Your ref:		<b>Please reply to:</b>	<b>Central Planning Team</b>
Our ref:	21/05508/FULL	Tel No:	2514
		Fee Queries:	0207 641 6500;
		Email:	planningreception@westminster.gov.uk;
Mr Matthew Jensen Fraiserline Architecture BASE Innovation Centre Broxhead House 60 Barbados Road GU35 0FX Hampshire		<b>Incomplete Applications</b> Development Planning City of Westminster PO Box 732 Redhill, RH1 9FL	18 August 2021

**Address: 173 New Bond Street, London, W1S 4RF**

**Proposal: Temporary installation of illuminated festive decorations for a period between 10th of November 2021 to the 6th of January 2022 and temporary removal of the existing flag and flagpole. (Linked to 21/05509/LBC)**

Proposed Truss Design

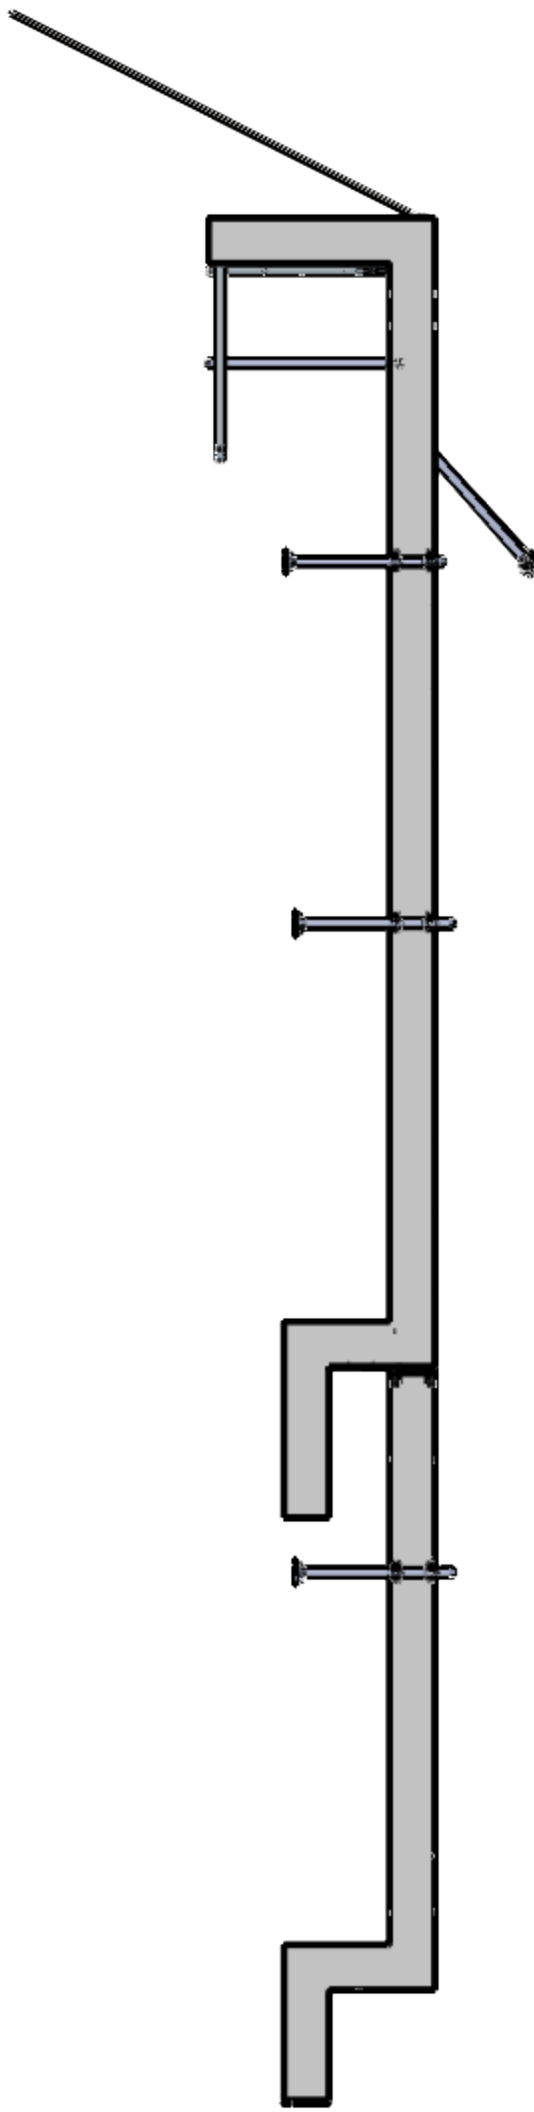
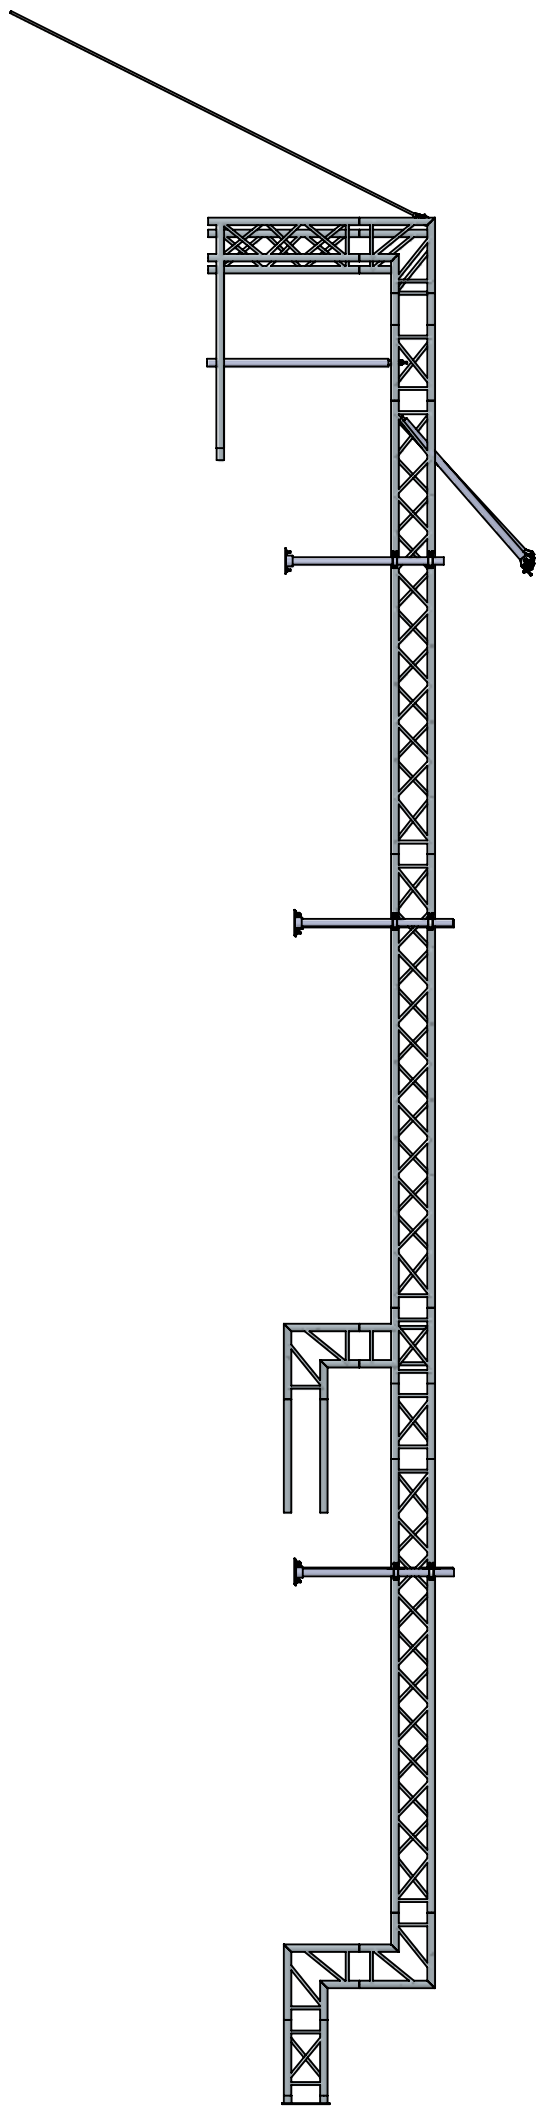
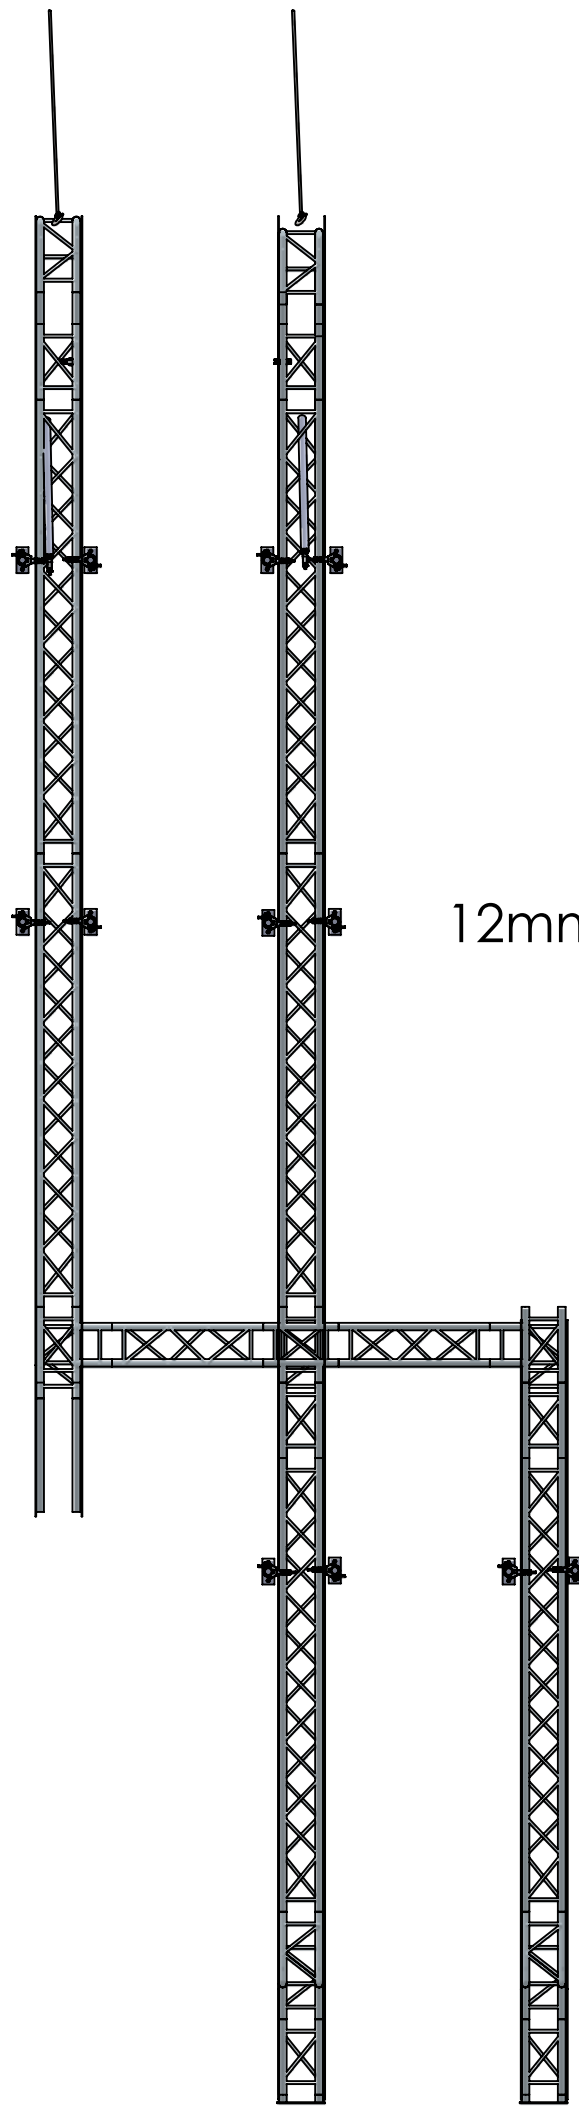
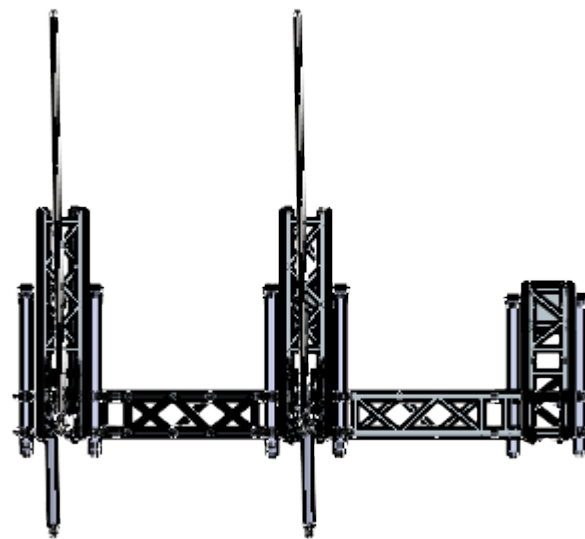
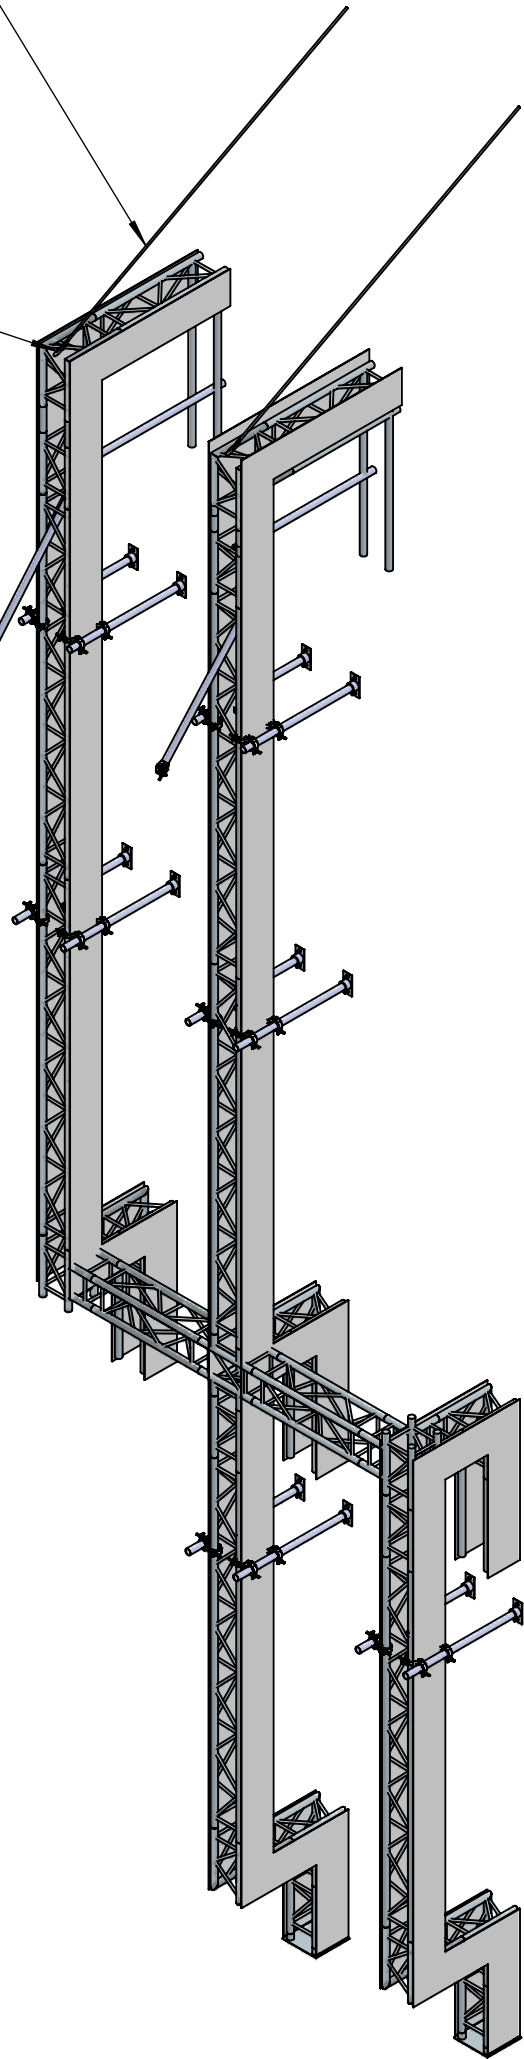
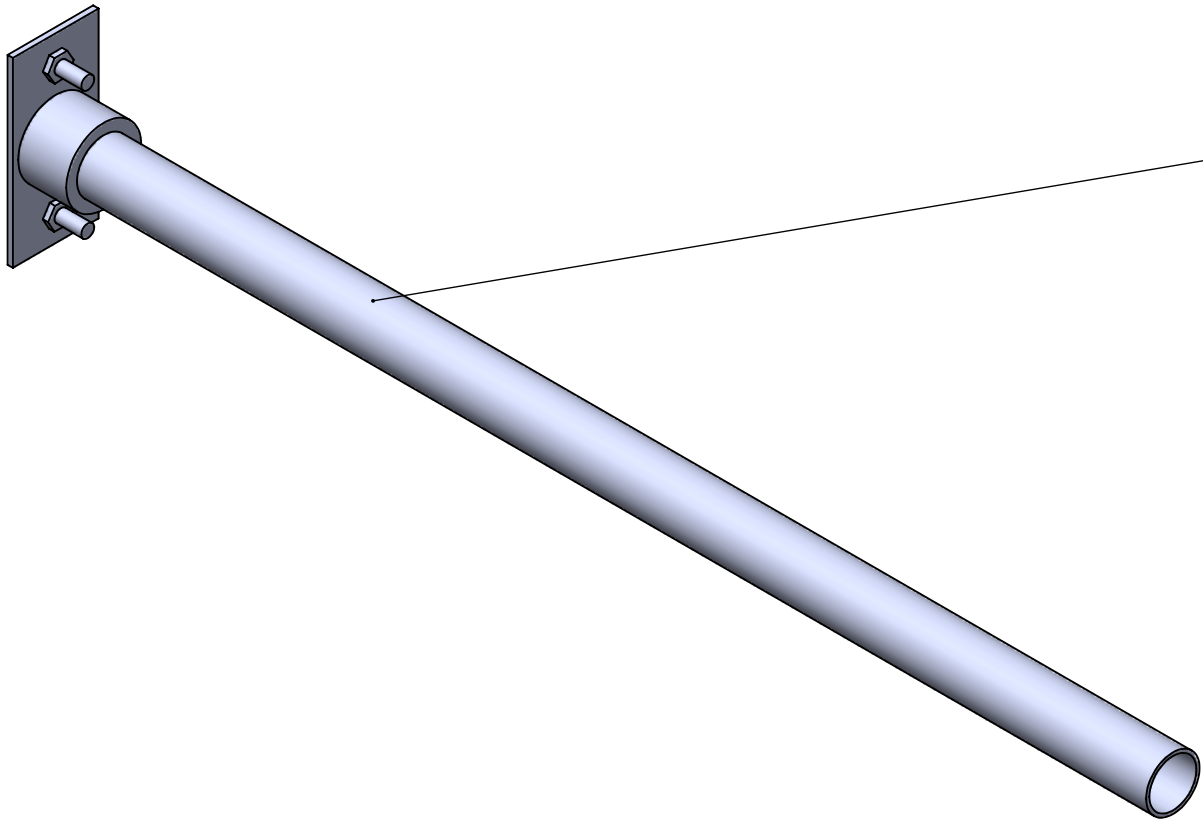
- 1 This is a structurally challenging installation that overhangs the pavement by a significant margin. Please provide a structural engineers method statement and full details of how the display is to be secured. The statement should include commentary on the ability of the existing building to carry the load of the installation and of the installation's ability to withstand wind and snow loads etc. without harm to itself or the building.
